Our Ref: ID 3273
Your Ref: SSD-73910208

Environmental Impact Assessment for Seniors Housing IRT Woonona Redevelopment

Elspeth O'Shannessy
Manager Emergency Risk Assessment
NSW State Emergency Service

FIGURE F52

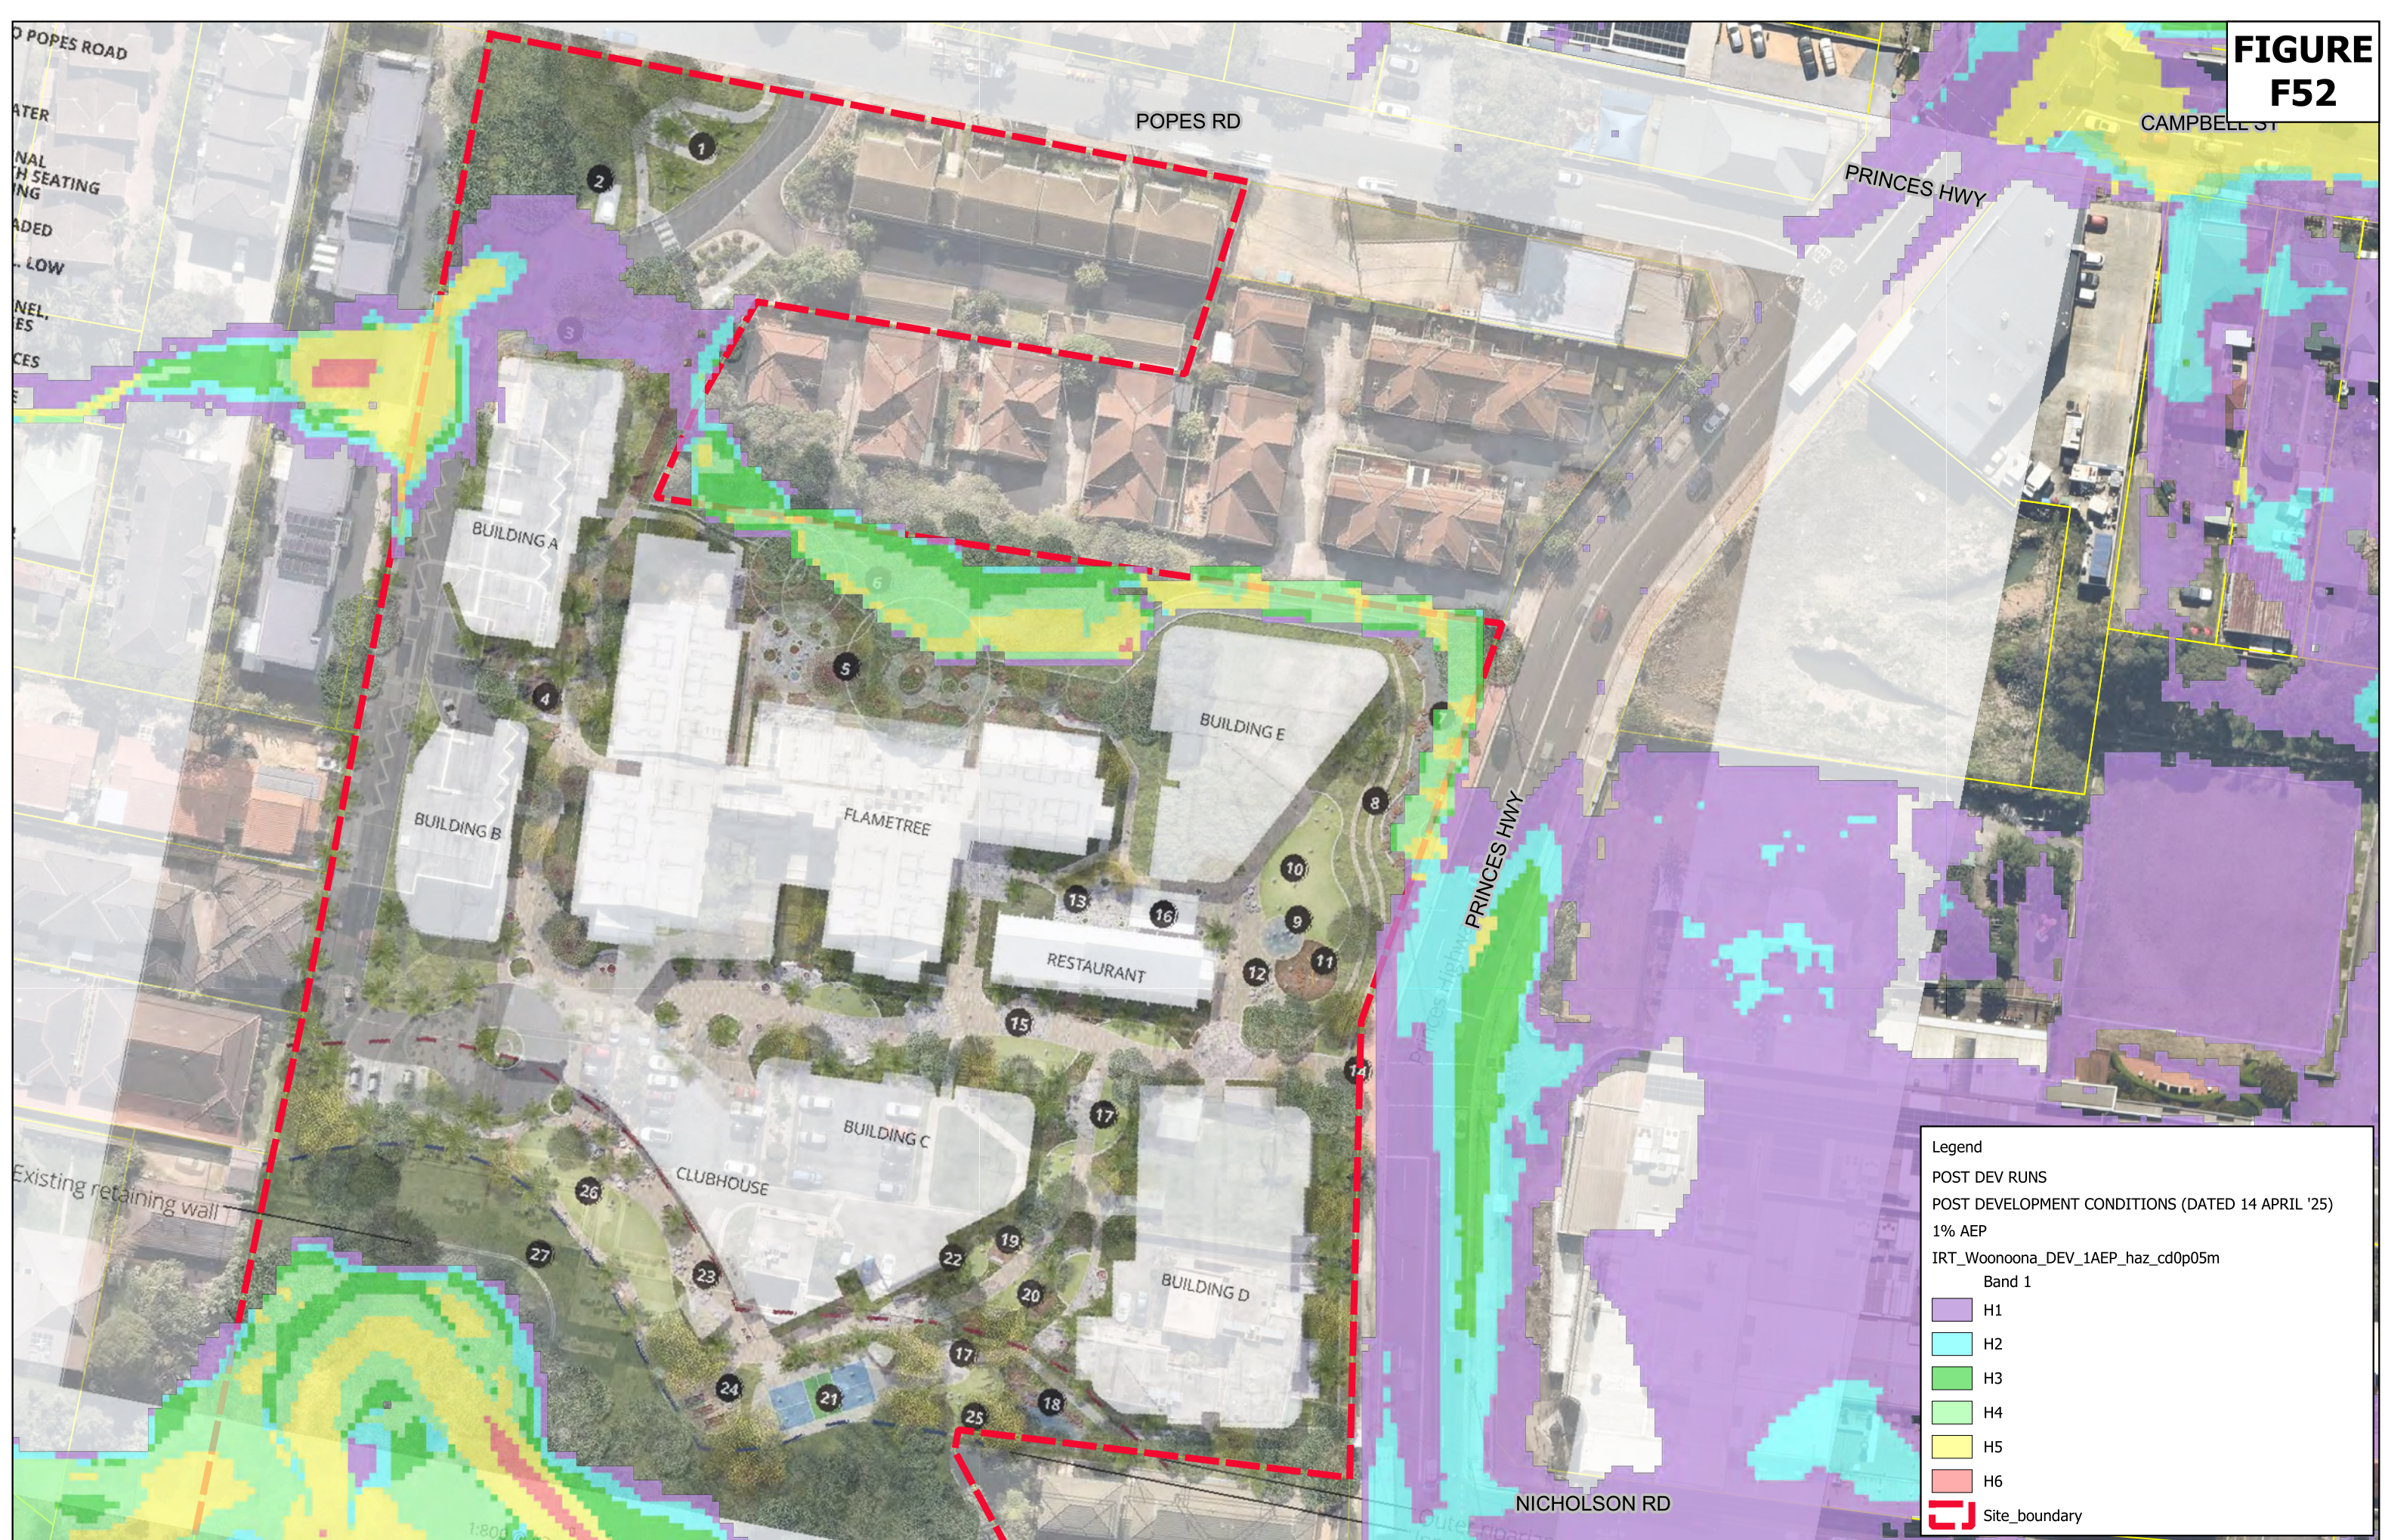
- the duration of flooding under various scenarios.
 - maps for the post developed scenario that show the flooding across the site, as currently the maps are zoomed in to exclude the highest flood risk area to the south of the site.¹

- more frequent flood events to understand the frequency of driveway flooding and potentially investigate design solutions to manage the risks
- the flood afflux up to and including the PMF
- the duration of flooding under various scenarios, including longer duration flood events
- maps for the post developed scenario that show the flooding across the site, as currently the maps are zoomed in to exclude the highest flood risk area to the south of the site.⁸
